Ribble Valley Borough Council
Council Offices
Church Walk,
Clitheroe
Lancashire
BB7 2RA

Phone: 0300 123 6780
Email: Kathryn.Walsh@lancashire.gov.uk
Your ref: 3/2024/1028
Our ref: 3/2024/1028/HDC/KW
Date: 31 March 2025

Location: Apple Tree Cottage 4 Orchard Cottages Branch Road Waddington
BB7 3HR
Proposal: Proposed single-storey side extension and internal alterations.
Grid Ref: 372959 443887

Proposed Rear Elevation  
Scale (1 : 100)

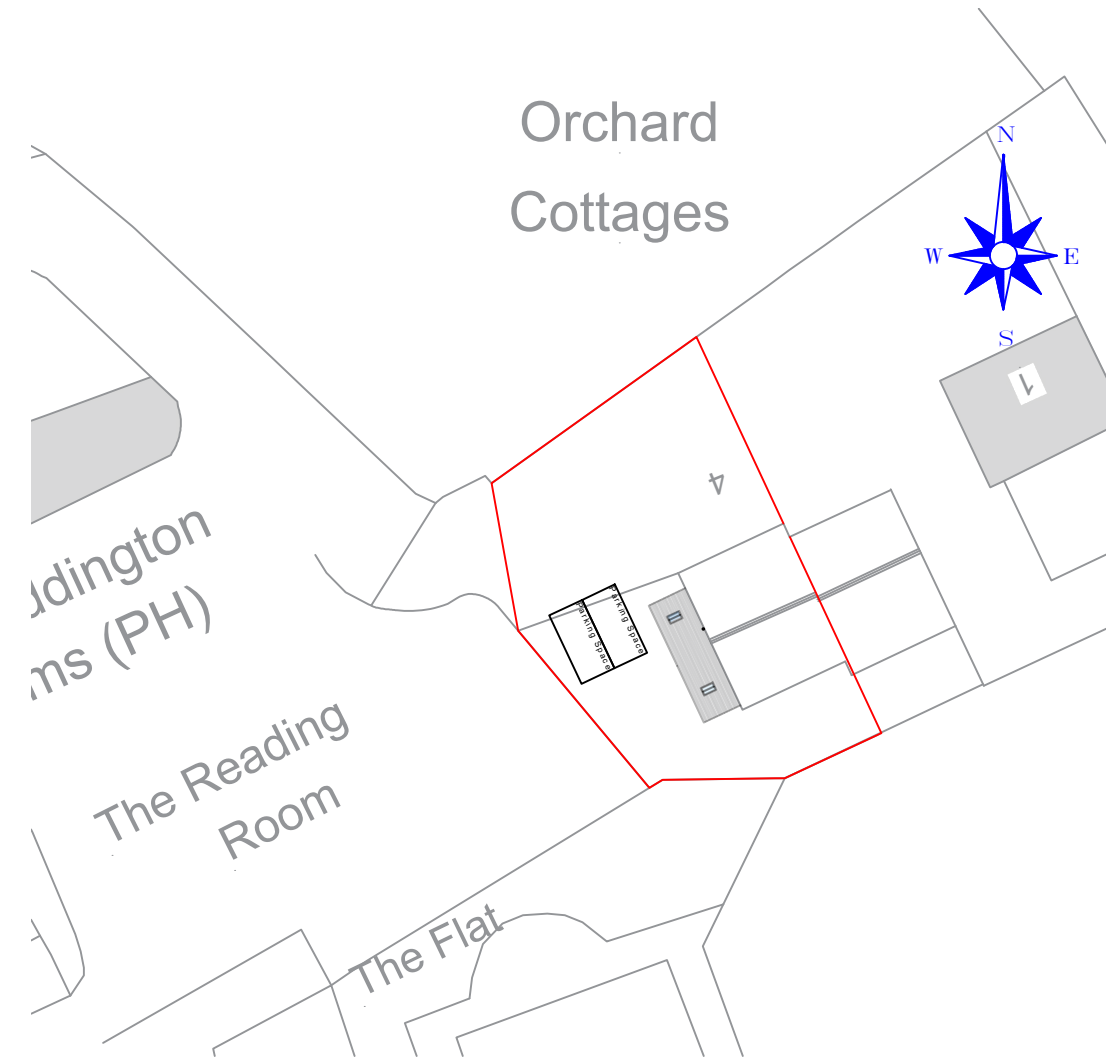
The LHA have reviewed drawing number 003 Revision D and note that there are 2 off street parking spaces which complies with the LHAs parking standards as defined in the Joint Lancashire Structure Plan.
